**Consultation Response from KC,
Highways Development Management****2025/91479 Rear of, 20, Halifax Road, Staincliffe, Batley, WF17 7BH****Outline application for residential development (3 dwellings)****Date Responded: 27/10/2025****Responding Officer: CNB****Responding Ref: K14-10NE/23**

This application is for outline permission with access and layout with all other matters reserved for a residential development of three dwellings within the garden of an existing dwelling with an existing access on to A638 Halifax Road, a 30mph two-way single carriageway main distributor road of approximately 10.5m width with a hatched central reserve, footways on both sides and street lighting present.

**DRAWING REF:** 25328-D02 **REV:** A

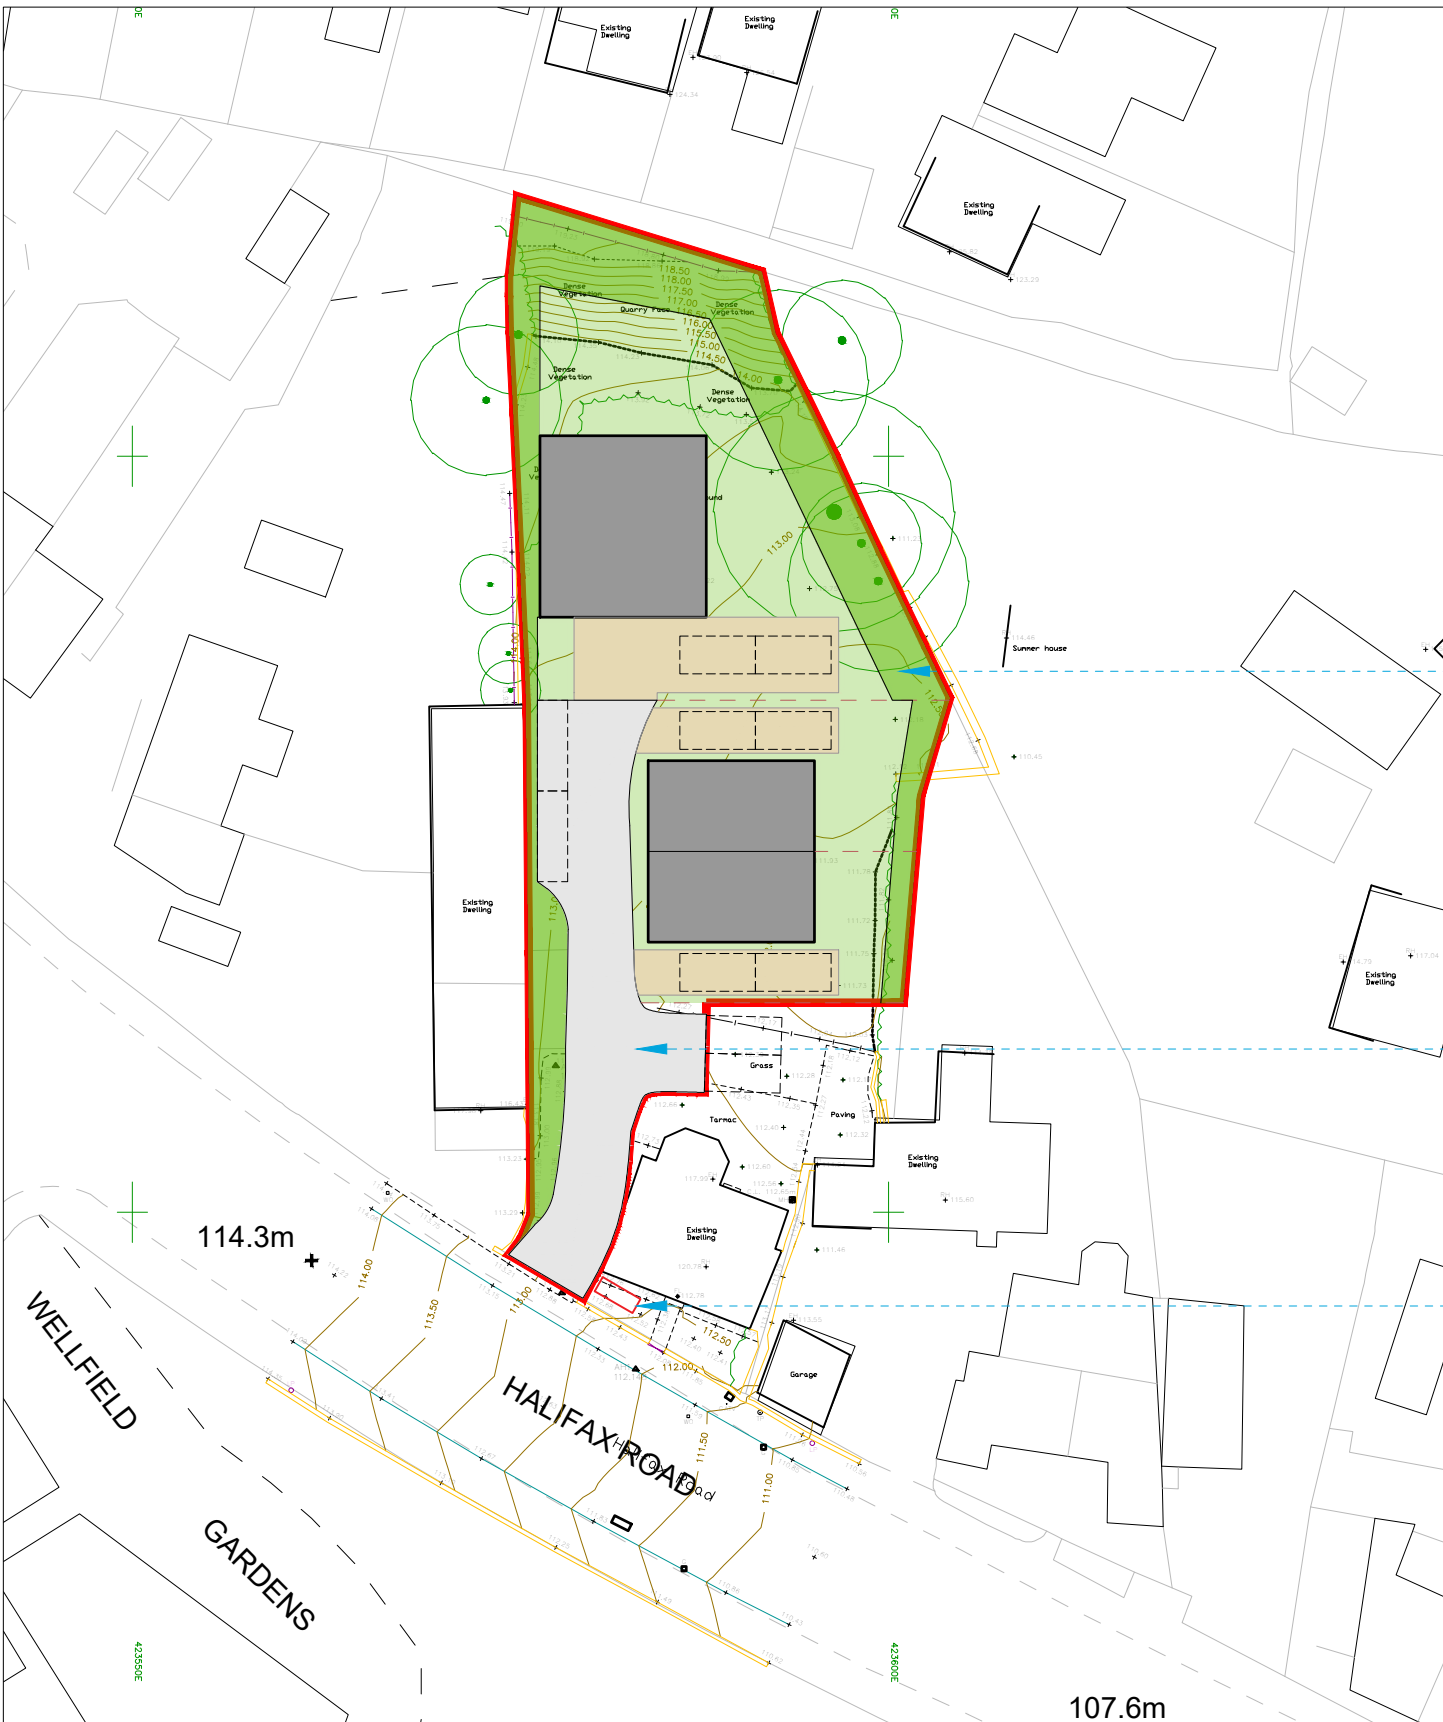
Both visibility splays and RSA were requested and supplied for the previous approval and so the applicant should have known that these would have been a requirement. The Design and Access Statement says, in Paragraph 4.01, “Access will be provided as approved in 2019”, however the submitted drawing 25328-D02 Rev A does not contain the additional details submitted in approved Drawing No 1911101 from the 2019 approval covering realignment and visibility splays.

The internal layout of the site remains similar to the previous permission with the driveway and turning area being retained. The layout has been amended slightly to allow for access to the revised parking spaces, but this is minor and would be acceptable. A swept path analysis will still need providing to show that all the parking spaces are easily and safely accessible and that vehicles can turn within the site so that they can enter and exit the site in forward gear.

It is noted that the existing donor dwelling only has two parking spaces shown, however the property was marketed as a 4-bedroom dwelling and so should have a minimum of three off road parking spaces. This should be clearly marked on the drawing.

Kirklees parking standards also require that for every 4 dwellings a single visitor parking space should be provided. There are what appears to be two visitor parking spaces shown on the drawing, however these are not marked as such and may not be suitable sizes for two tandem spaces and would require a swept path analysis to show that they were safely accessible and that cars parked in them would not obstruct access to the residential parking spaces.

Drawing No 25328-D02 Rev A shows two parking spaces per dwelling and, based on local parking standards, this would only be suitable for dwellings of no more than three bedrooms.

Title
 Proposed Access
 Arrangement

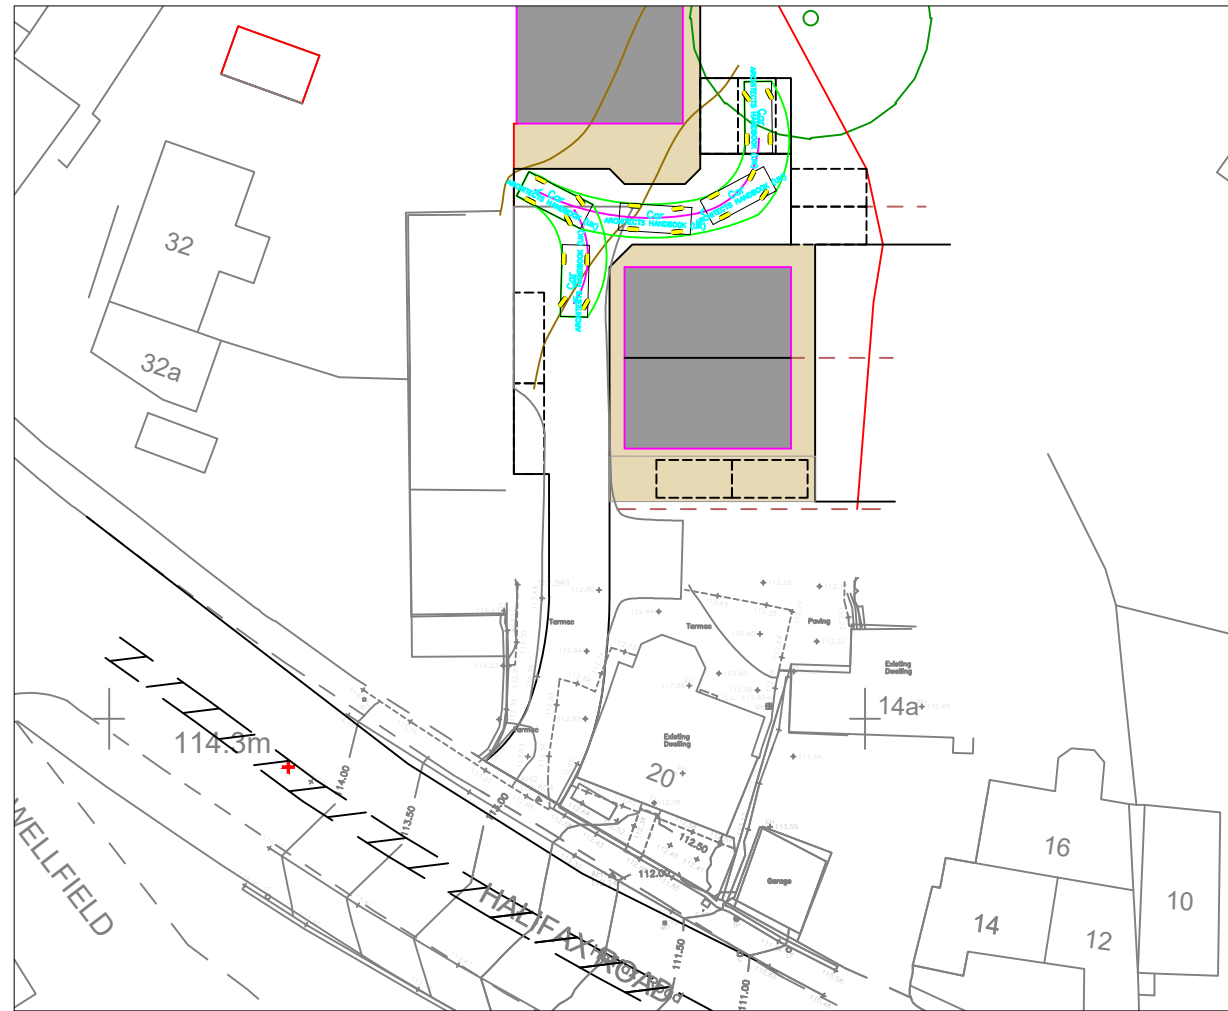
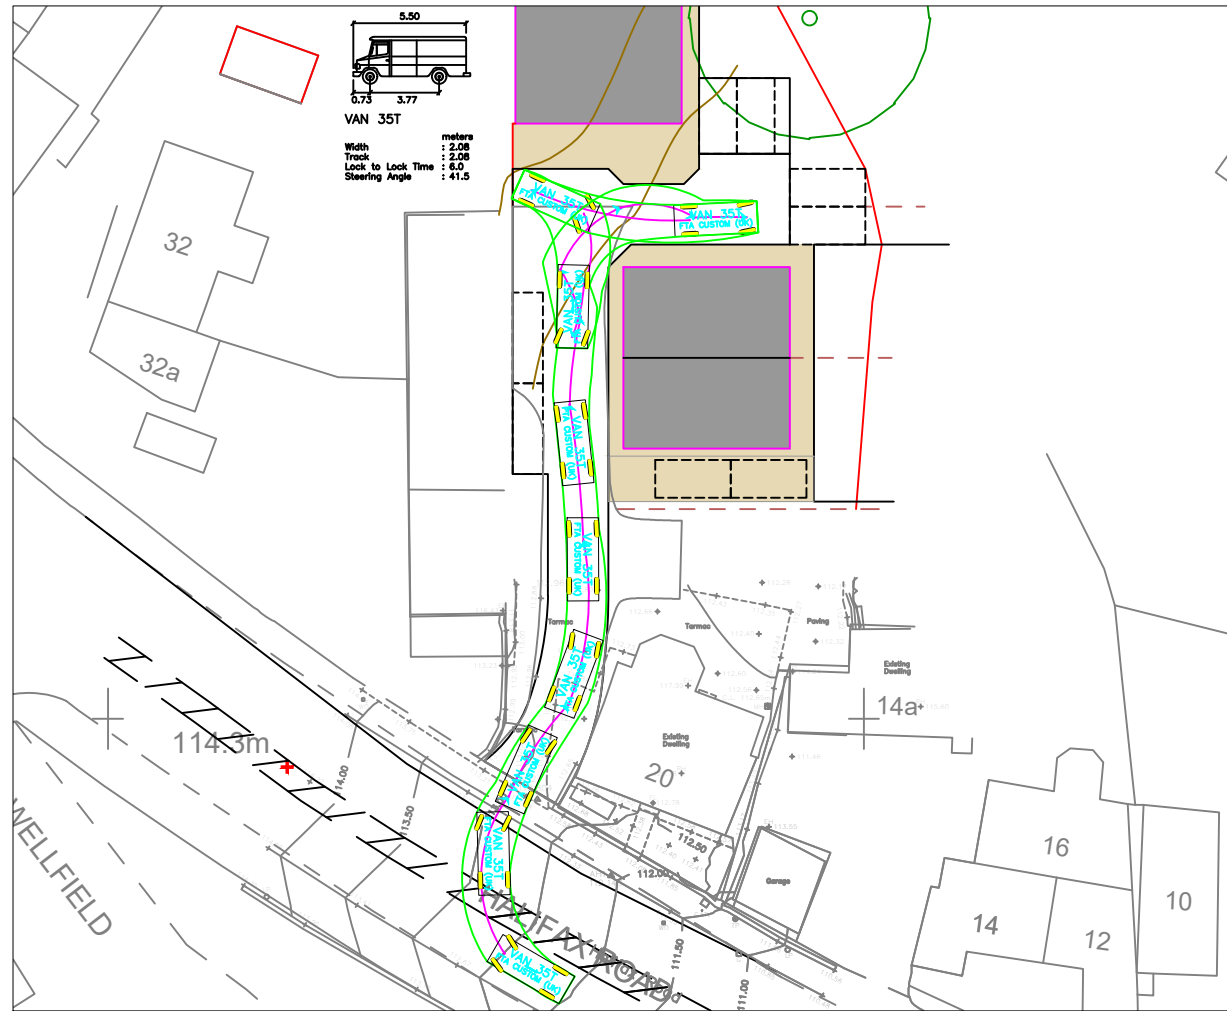
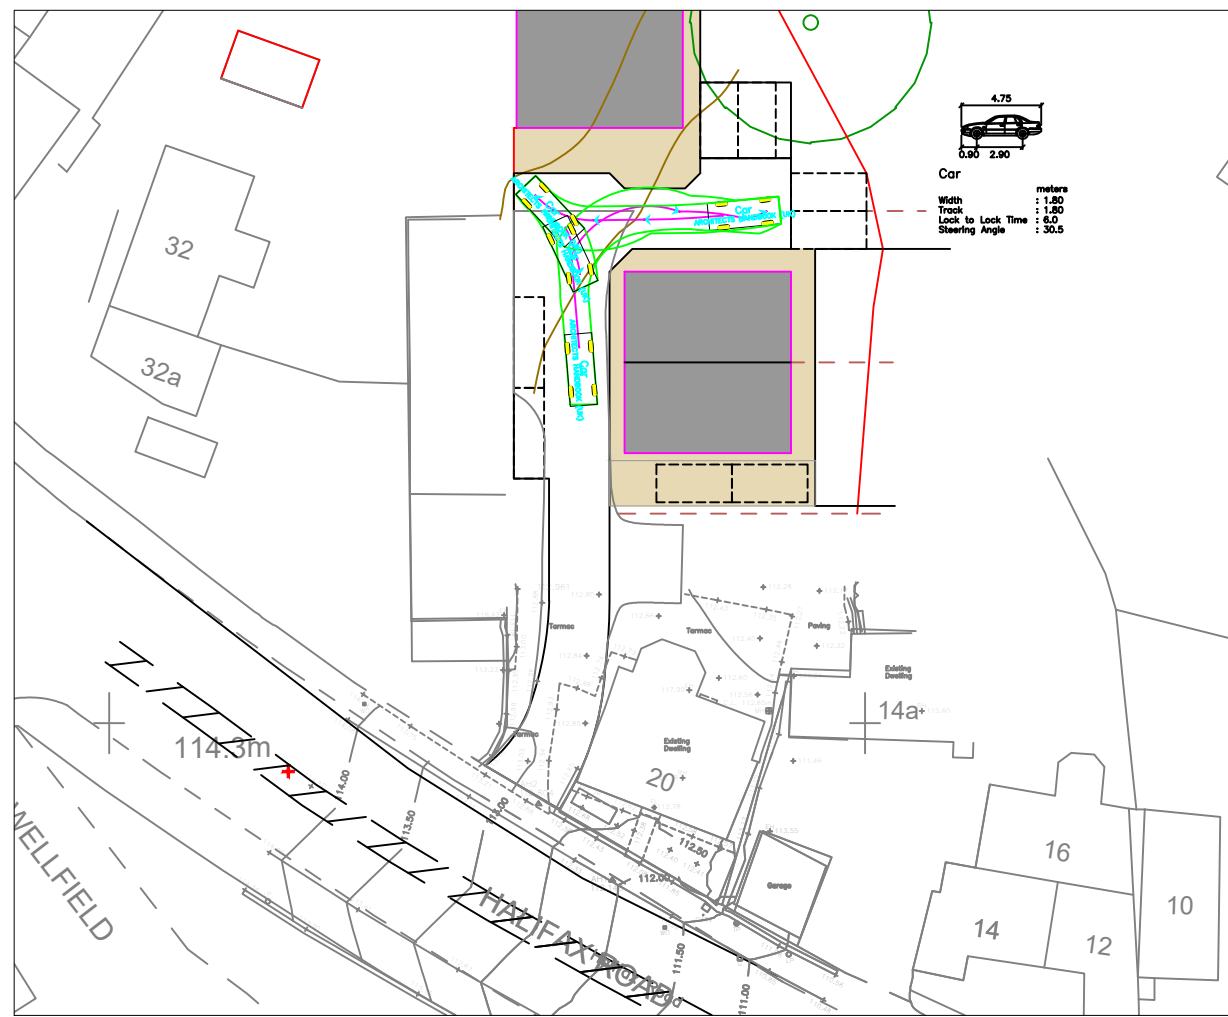
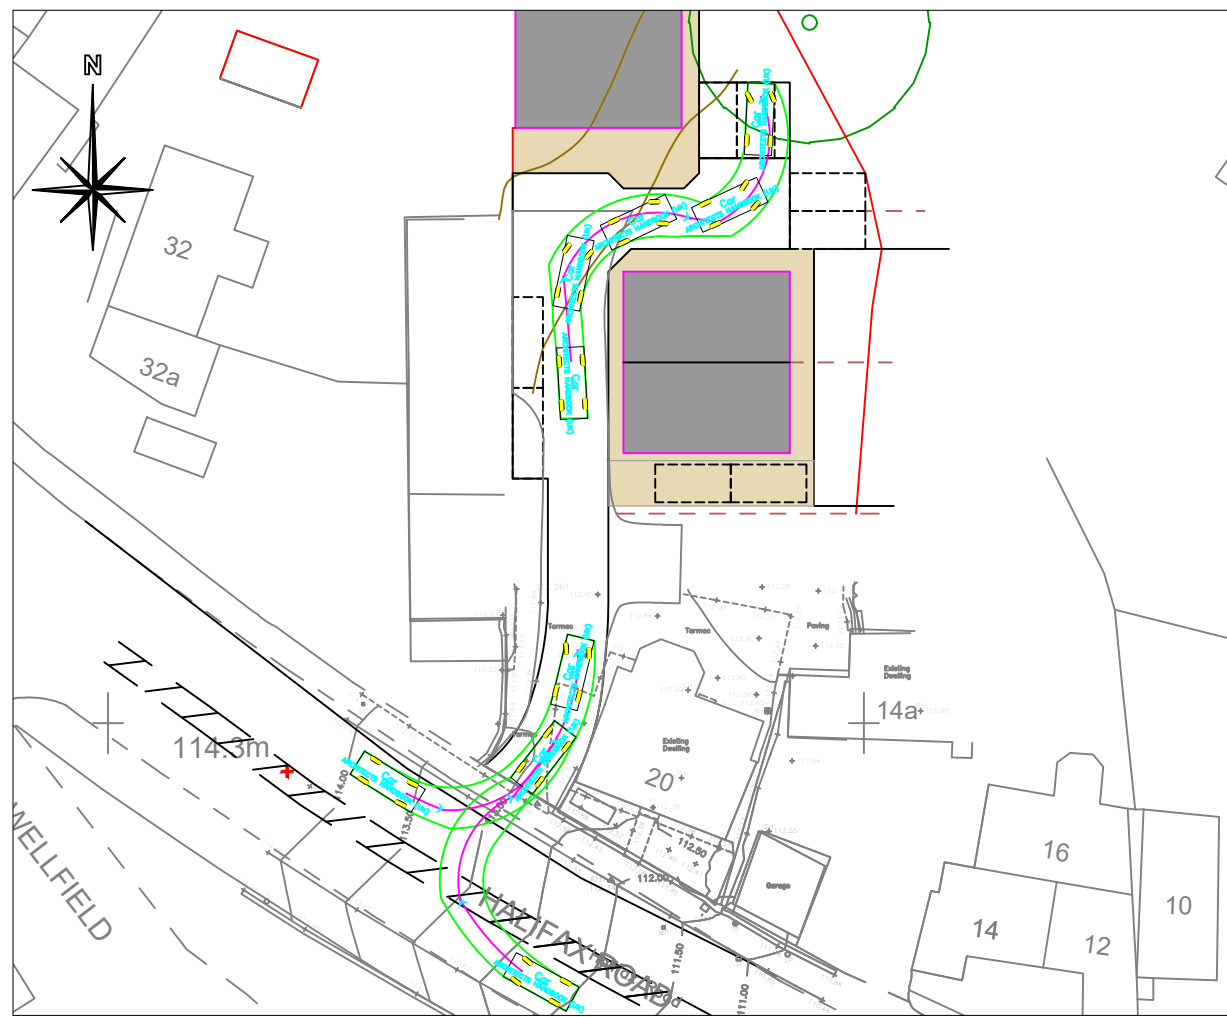
No visibility splays have been submitted with the application, and these should be a minimum of 2.4m x 43m for a 30mph road. With the previous approval the visibility splays were only achievable after a speed survey had provided an 85th percentile speed to re-calculate the splay y-lengths and still required a “build-out” in order to achieve them.

Without an indication that the safe visibility splays can be achieved we cannot currently support the proposed access to the site. If a build out was required this should take the form of a re-kerbing of the footway to push out the x-length on the visibility splay to allow a sufficient y-length to be achieved, the re-marking of the central hatching will also be required as the movement out in the path of vehicular movement will cause additional wear on the existing hatched markings and so a suitable lane width will be required to avoid this additional maintenance responsibility.
